# TRAFFIC IMPACT STUDY

**3980 Walker Road  
El Paso County, Colorado**  
PCD File No. PPR2350

April 2024  
Revised June 2024

Figure 2
CONCEPTUAL SITE PLAN

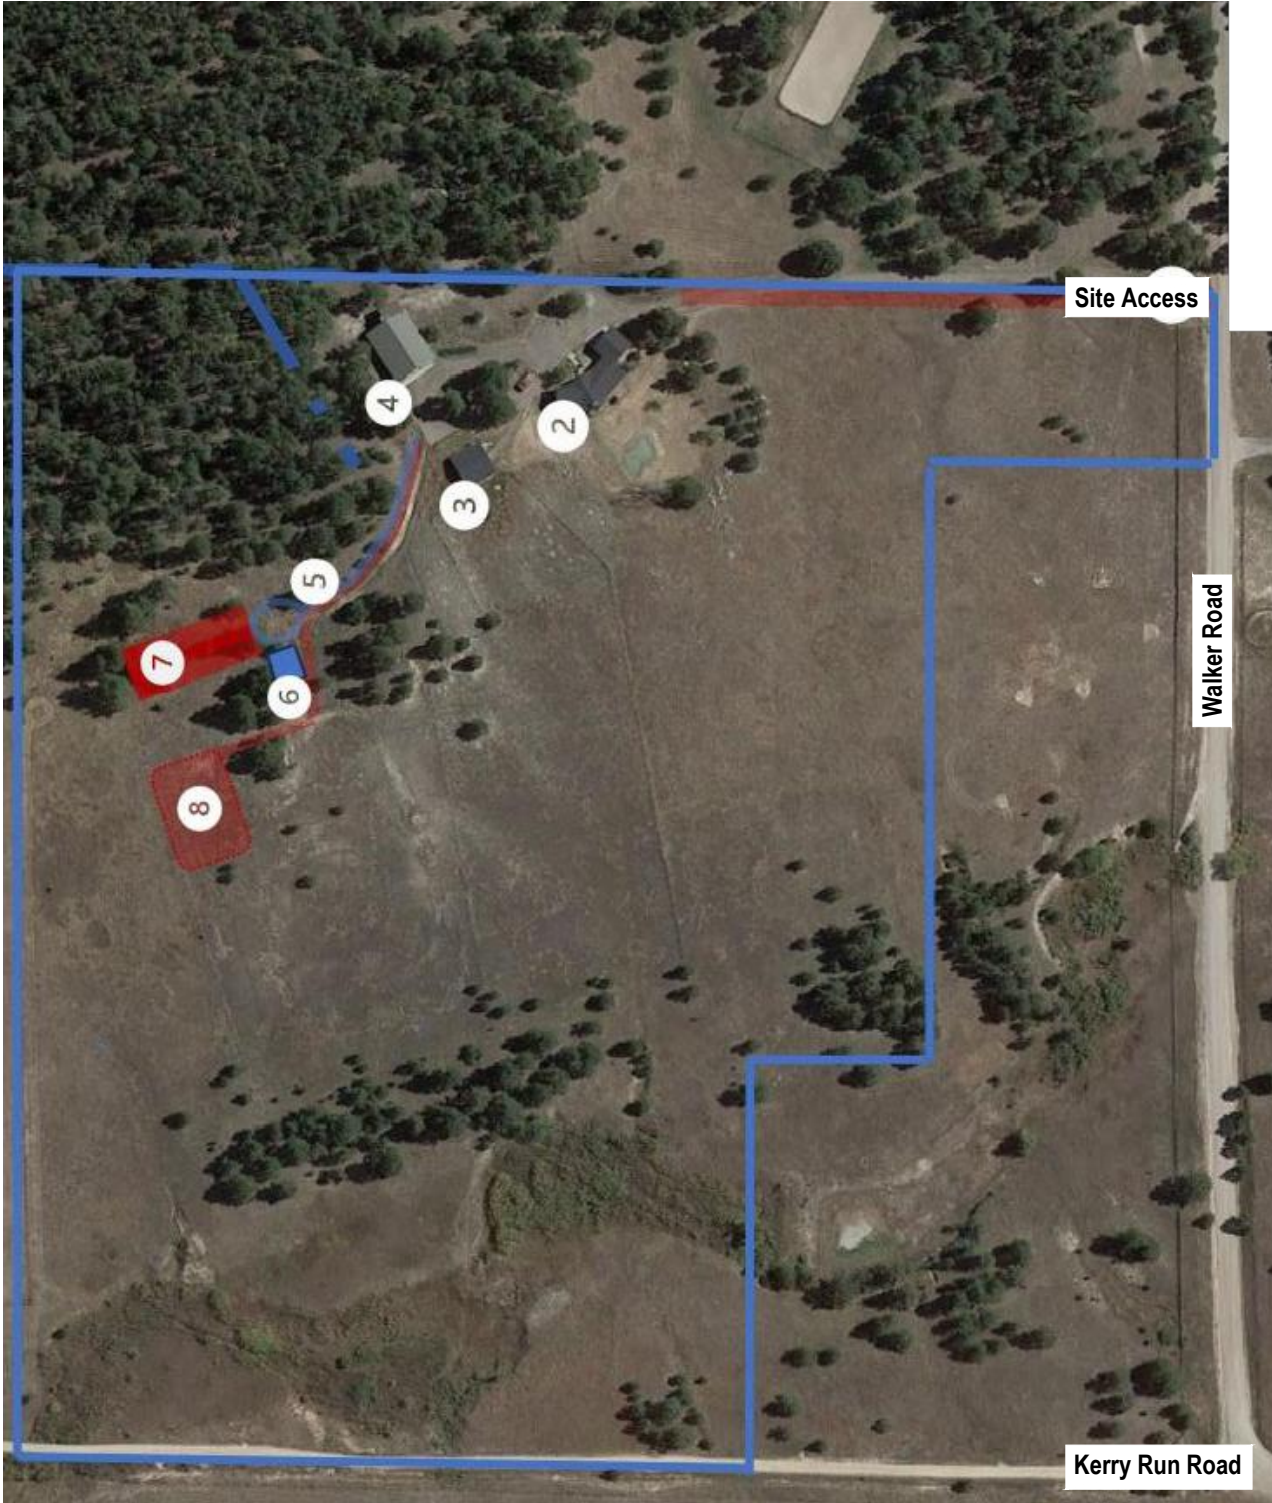
Unresolved: Per ECM section B.3.3.A, trip generation shall be calculated from the latest data contained within the Institute of Transportation Engineers' Trip Generation Manual. Please provide a basis for the trip generation. Coordinate with the applicant to provide more clarity as to the intended uses so that a more accurate trip generation can be provided. Per meeting on 8-13-2024, please fully define the parameters of the use moving forward, submit with a comparable use from the ITE, pinpoint exactly what you are asking the County to approve. Phasing of the project could be used as a limitation.
